IN RESPONSE TO ITEM 5.1 & 5.5
REFER TO DRAWING NO. KSG4-CSC-XX-XX-DR-C-0036
WHICH SHOWS ADEQUATE MANOEUVRABILITY IS ACHIEVABLE WITHIN THE PROPOSED DEVELOPMENT AND ADEQUATE STOPPING DISTANCES HAVE BEEN ACHIEVED.

Architect	Project	Title
DTA	Kishoge Part 10 Application	Site 4 Quality Audit
Date	08/02/25	08/02/25
Scale	1:500	1:500
Author	SC	JF
Checker	SC	JF
Approver	SC	JF
Reviewer	SC	JF
Final	SC	JF

PLANNING DRAWING.
NOT FOR CONSTRUCTION.
ALL LEVELS GIVEN ARE
RELATIVE TO ORDNANCE DATUM.
THIS DRAWING HAS BEEN ISSUED FOR INFORMATION
PURPOSES ONLY AND MUST NOT BE USED
FOR CONSTRUCTION UNDER ANY CIRCUMSTANCES

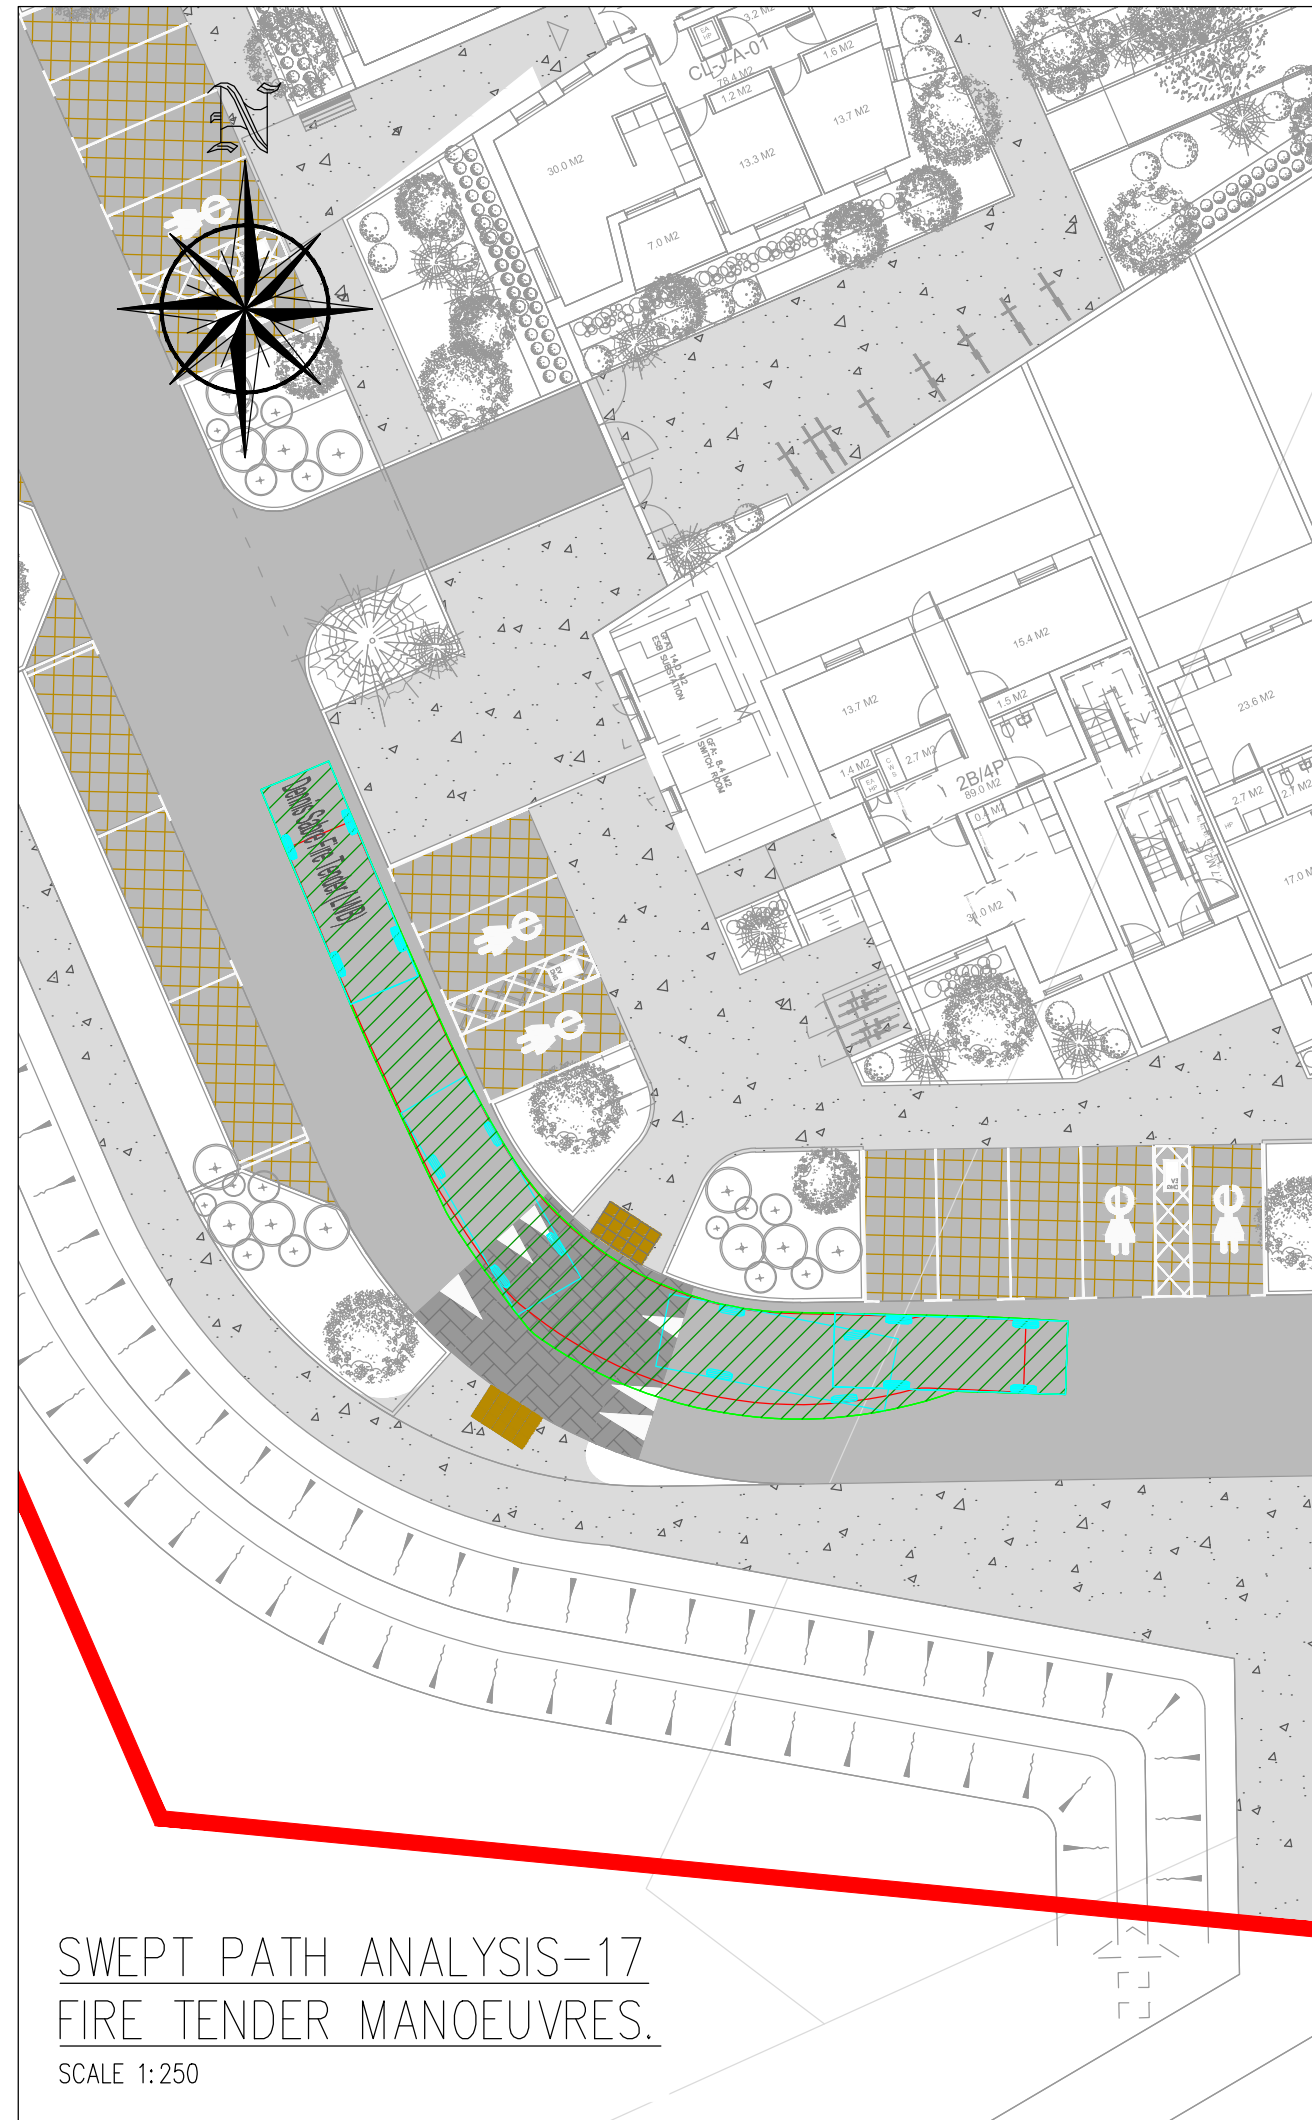
IN RESPONSE TO ITEM 5.2
REFER TO DRAWING NO. KSG4-CSC-XX-XX-DR-C-0016 & 0017
WHICH SHOWS ADEQUATE FIRE TENDER AND REFUSE VEHICLE MANOEUVRABILITY IS ACHIEVABLE WITHIN THE PROPOSED DEVELOPMENT.
